Appeal Decision

Appeal Ref: 6013858

88 Stormount Drive, Hayes, Middlesex UB3 1RH

- The appeal is made under section 78 of the Town and Country Planning Act 1990 (as amended) against a refusal to grant planning permission.
 - The appeal is made by Mr Shammi Kohli against the decision of the Council of the London Borough of Hillingdon.
 - The application Ref is 38576/APP/2026/583.
 - The development proposed is described as the erection of a first floor side and rear extension above the existing ground floor footprint, construction of a ground floor rear extension, installation of rooflights, and erection of a front porch, together with associated internal alterations.
-

Drawing Title:
Proposed Elevations
B & C
Drawing No.:
88ST-03-2026

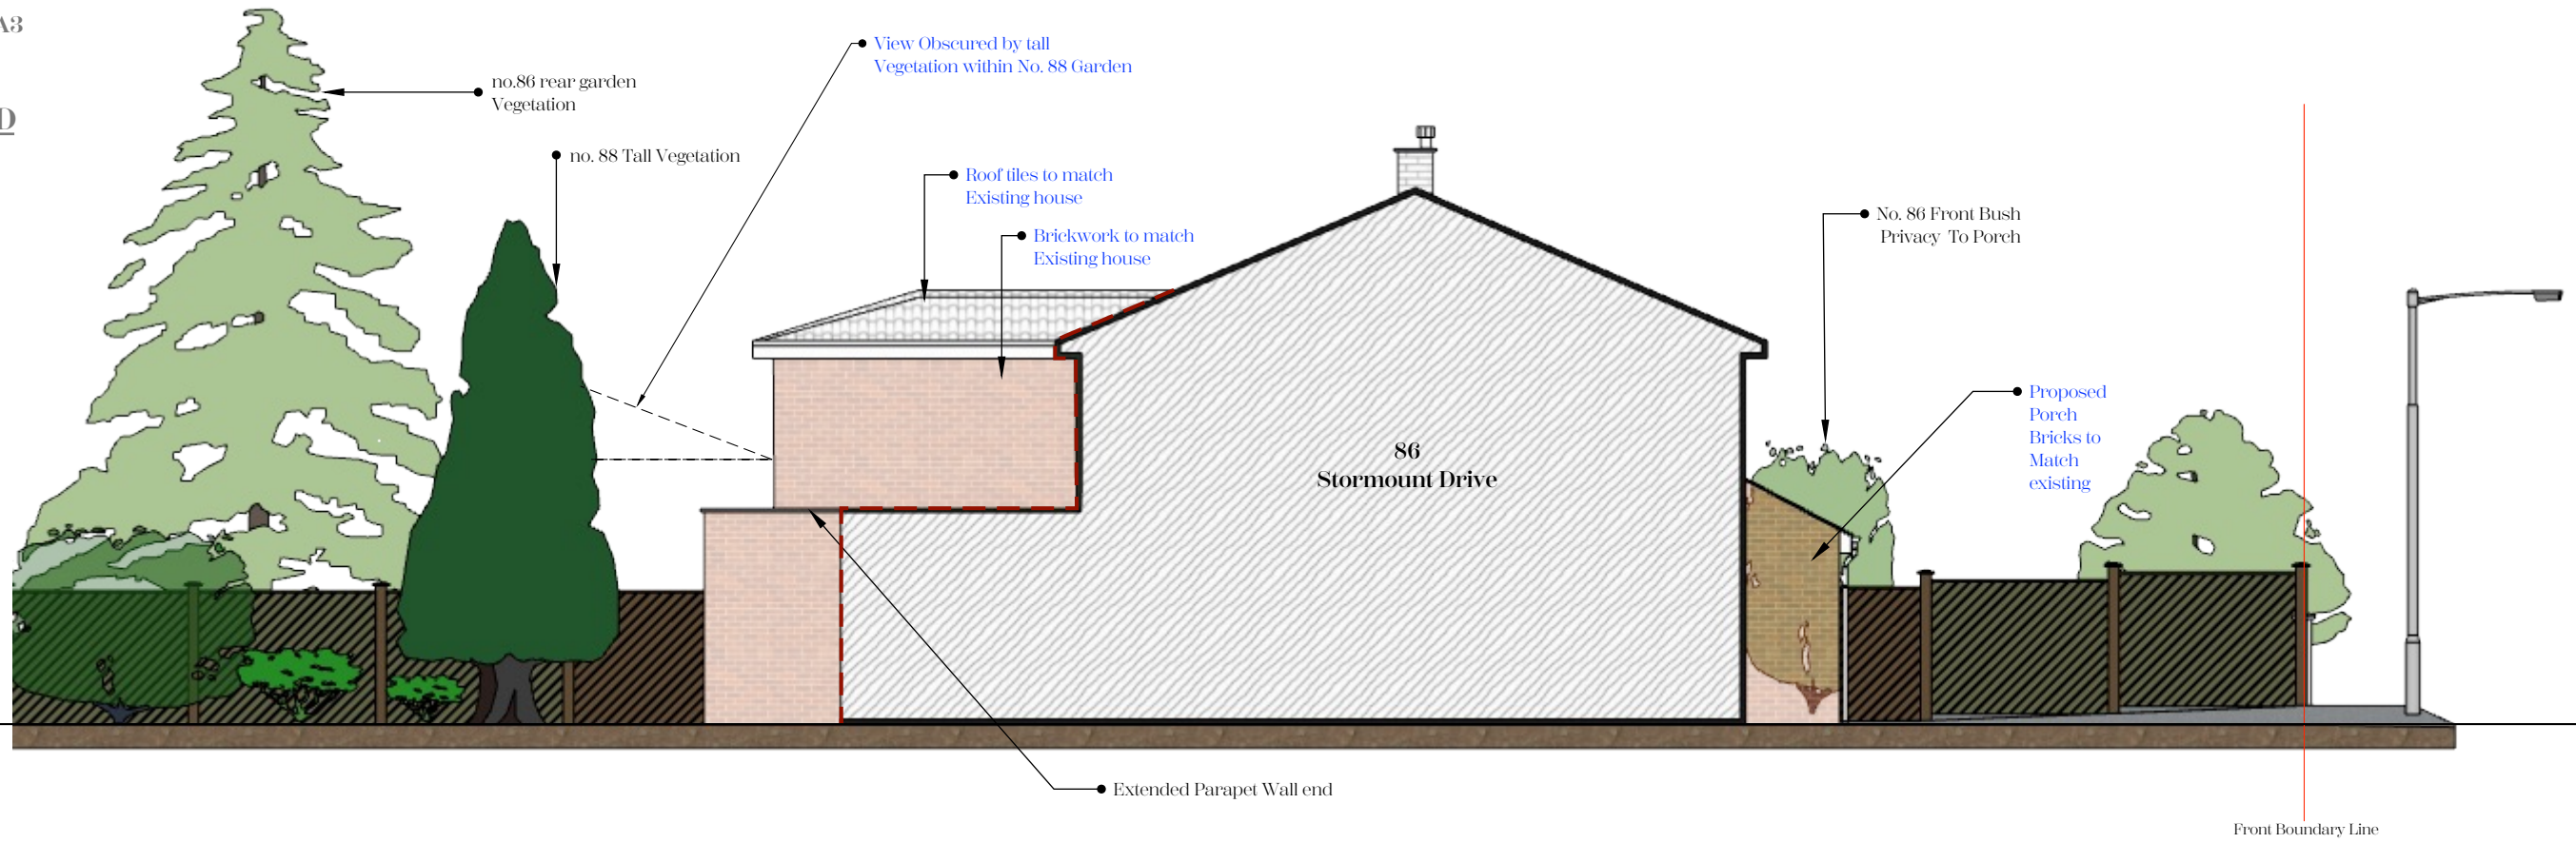
- 4) The first floor side extension hereby permitted shall not be occupied until its side facing windows as depicted on drawing number 88ST-013-2026 have been fitted with obscured glazing, and no part of those windows that is less than 1.7 metres above the floor of the room in which it is installed shall be capable of being opened. Once installed the windows shall be retained as such thereafter.
